Submission No.			006	
Organisation Name or Name of Submitter			Amanda Hughes (resident - 9 Berkeley Road, Phibsborough)	
Item No.	Section Ref.	Page No.	Observation Statement	TII Response
Letter Re: Railway Order Application - Metro North: Estuary through Swords, Dublin Airport, Ballymun, Glasnevin and City Centre to Charlemont, Co. Dublin: Railway Order 2022 (Metrolink-Estuary to Charlemont via Dublin Airport)				
1	Mater Stop	1	I sincerely hope that the construction of the Mater stop provides an opportunity for the rejuvenation of the area rather than it being viewed by TII as a convenient site for a station with no regard for the architectural environment and the communities living near the area.	<p>Thank you for your submission and for sharing your concerns/observations related to the Mater station.</p> <p>The station will benefit the local community hugely. The architectural plans for Mater Station have been prepared to integrate the station into the park in a sympathetic fashion with the skylights being framed by planting and providing circulation routes through the park. Existing monuments and protected railings will be removed temporarily during the construction and will be

MATER STATION

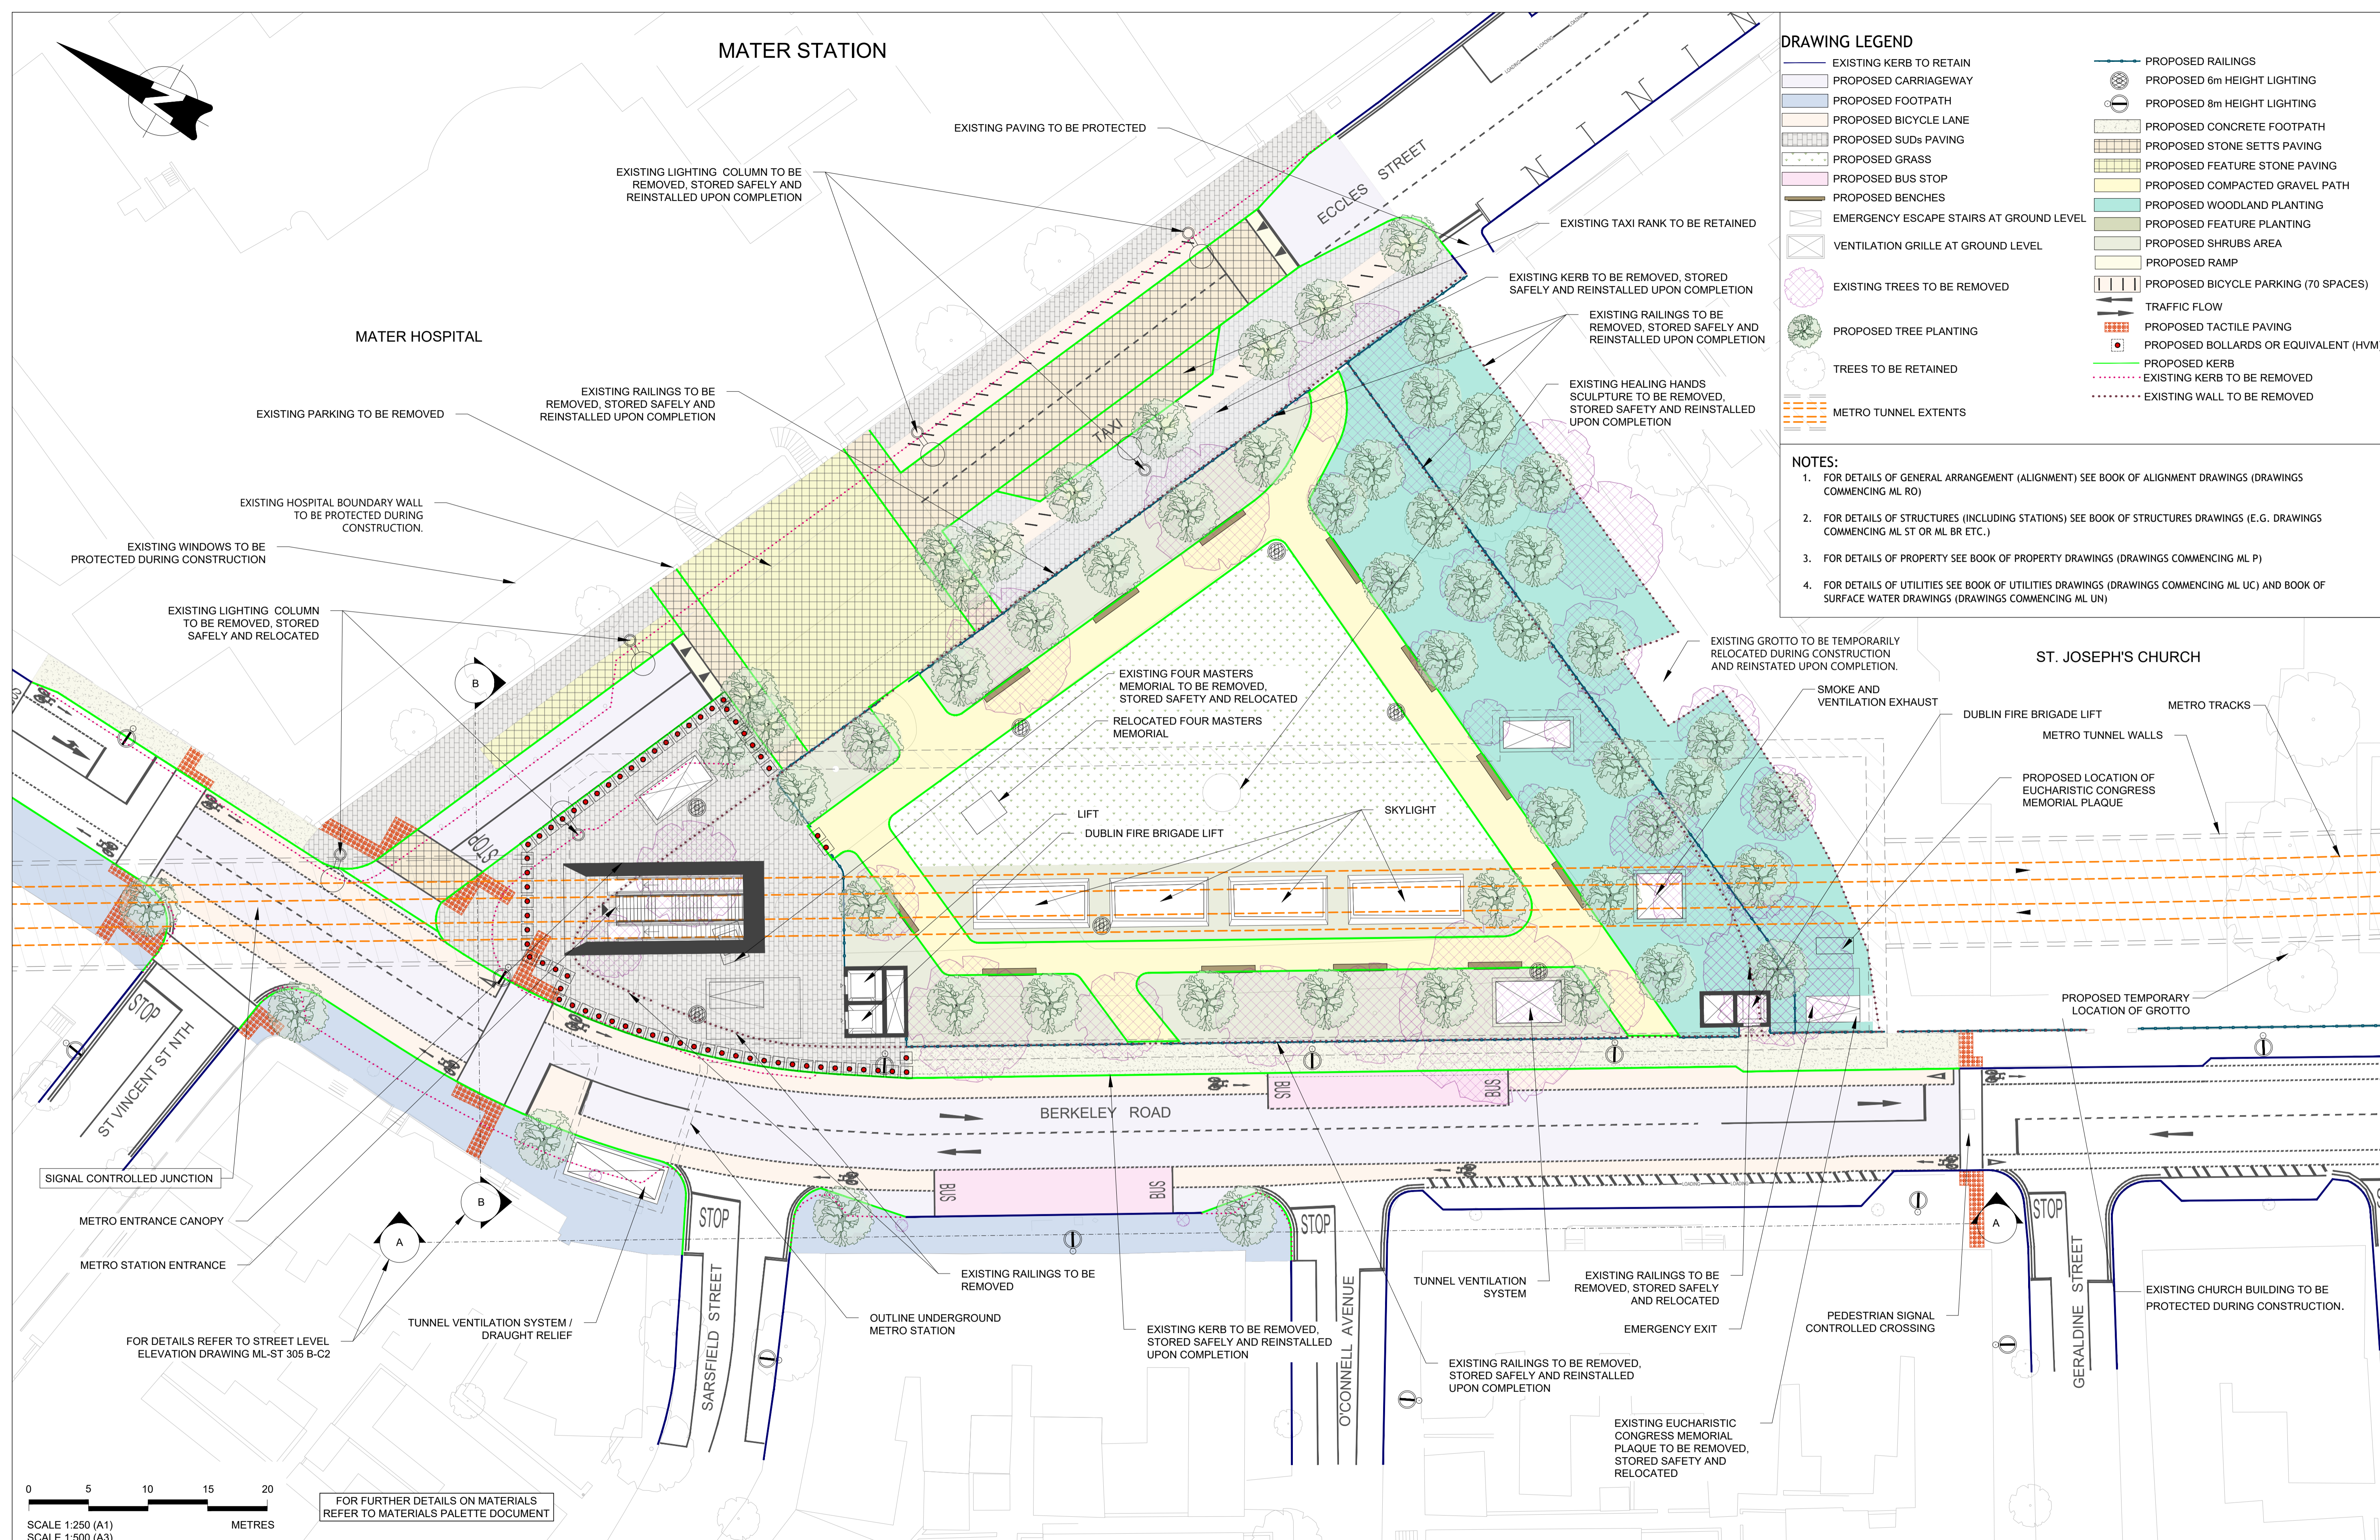
2	Mater Stop station Design	1	I am extremely concernd about the design and location for the Mater Stop and the anciliary structures. The correct design for the area will enhance rejuvenation end positive redevelopment after the 9 years of construction whereas an unattractive utilitarian design approach to the station and The Four Masters Park may have a very adverse effect on an area that has huge potential for being a really positive asset in the North Inner City and Phibsborough village. To compliment the location I feel that the canopy of this station should have less footprint, elevation and visual impact.	<p>The entrance is appropriate and conveniently located to walk to Mater Hospital, St Joseph’s Church and Berkeley Road. The station location will also connect with bus services to and from Dublin City Centre, with bus stops on Berkeley Road.</p> <p>The Mater Station urban realm design principles are based on the following:</p> <ul style="list-style-type: none">* Realignment of the Four Masters Memorial;* Rearranging the footpath to provide enough pedestrian space for the main entrance;* Reinstatement with enhanced planting of the Four Masters Park and its existing railings; and* Replacement of existing trees. <p>The landscape design creates a public plaza to the main arrivals area at the entrance/exit. This active plaza then provides access to Eccles Street and Berkeley Road. A shared surface plaza to Eccles Street will be created to provide greater connectivity to the adjacent existing pedestrian network. This plaza will frame the portico of the adjacent Mater Hospital and integrate pedestrian circulation and cycle parking within the streetscape. On completion of the station, the park will be reinstated in a similar fashion to its current condition. Prior to construction commencing and in order to complete the urban integration, existing railings, Four Masters Memorial, Healing Hands Sculpture and other existing features will be carefully removed and stored temporarily to be reinstated into the urban landscape as part of the completion works.</p> <p>Please refer to response item (5) below in relation to the station design at Mater, and the design principles across the Project.</p>

3	Mater Stop station Design - 1) Elevation and position of the station entrance	1	The view of the Mater Hospital building will be blocked from Berkeley Road. With either a different canopy design or using a different location in Four Masters Park would have a very positive effect on the commercial potential for Berkeley Road. The ancilliary buildings (lifts, emergency exit, ventilation shafts, lights) further block the view into the park visually shutting the off the park from Berkeley Road and diminishing any sense of space in the street.	<p>Please refer to responses (1) and (2) above and also refer to Chapter 27 (The Landscape) and section 27.5.4.20 of the EIAR which considers the landscape and visual impact of the project at Mater.</p> <p>Upon completion of the proposed Project, the visual amenity of the area will be largely restored, much to its existing condition though with some minor improvements. The green park will be restored close to its existing condition within the triangle of buildings along with the proposed amendments also made to the original Mater Hospital section of Eccles Street, which will enhance and transform the area around the station on completion. See also Landscape Photomontages LLCA 19: V19.1 to 19.5.</p>

4	Mater Stop station Design - 2) Materials used in the design of the station entrance	1	These are inappropriate for this location, it is an architecturally sensitive area and zoned under Objective Z2 in the Dublin City Development Plan 2022-2028. The buildings on Berkeley Road and street are Victorian and made of red brick, while the Mater Hospital and St Joseph's church are made of granite, the proposed Mater stop station is a glass structure with heavy looking brown detailing, the emergency exit is of brown brick and resembles a public toilet.	<p>Section 26.4.4.8 Mater from the Chapter 26 (Architectural Heritage) of the Environmental Impact Assessment Report (EIAR) describes the architectural heritage features present in the area of Mater Station and their protection status.</p> <p>As stated in section 25.4.3.3 of EIAR Chapter 25 (Archaeology & Cultural Heritage), Berkeley Road is an Area of Archaeological Potential and TII strongly believe that the proposals presented under this Railway Order are sympathetic to and will enhance the area further upon completion. When the works are completed, the visual amenity of the area will be largely restored, much to its existing condition though with some minor improvements. The restoration of the open green park space within the triangle of buildings along with the proposed amendments to the original Mater Hospital section of Eccles Street. Overall, the predicted effects on the visual environment and on visual amenity after the Mater Station is completed will, in the longer term be significant and positive.</p>

6	Mater Stop station Design - 4) Station entrance location	2	Relocating the station entrance to face the side walls of St Joseph's church on Berkeley Road would allow for the entrance / exit to be onto Eccles St. This location provides a more visually and softer view of the station entrance because it could be surrounded by trees as in the Stephens Green montage, it would also allow for the relocation of the ventilation shafts, lifts and emergency exit to be relocated resulting in the opening up the vista of the Four Masters Park, and the Mater Hospital.	<p>The location of the station entrance is driven to optimise pedestrian access and flows both to the pedestrian crossings at the north corner of Eccles Street and Berkeley Road, and to facilitate the connection to Mater Hospital both to the canopy and to the lifts which have been duplicated in this particular location.</p> <p>Relocating the station entrance face towards St. Joseph’s Church complicates, lengthens and hinders these flows and movements. Additionally, this provision affects a part of the park that has a certain level of protection and is fenced with railings.</p>

7	Mater Stop station Design - 5) Pedestrian safety / alternatives	2	Locating the station entrance further into the park near St Joseph's church would be safer for station users to enter and exit the station. In its proposed current location there is a great risk of pedestrians running across roads to the station as the proposed entrance is located very close to a cross roads (Berkeley Road, Eccles St and Vincents St). There is a proposal to pedestrianise Eccles St which will make it a safer entrance. It will also be safer to have the emergency exit located on the Eccles St side of the park rather than beside Berkeley Road which is a busy road at peak times.	Please refer to response (6). The safety of the design is fundamental to TII and the risks noted have been addressed. The design includes the signalisation of the junction of Berkeley Road, Eccles Street and St Vincent’s Road North. The width of Eccles Street will be reduced locally at the junction. Provision of shared space will be incorporated on Eccles Street in the vicinity of the junction with Berkeley Road, with the shared space demarcated from the road edge by a raised kerb for the safety of pedestrian and cyclists.
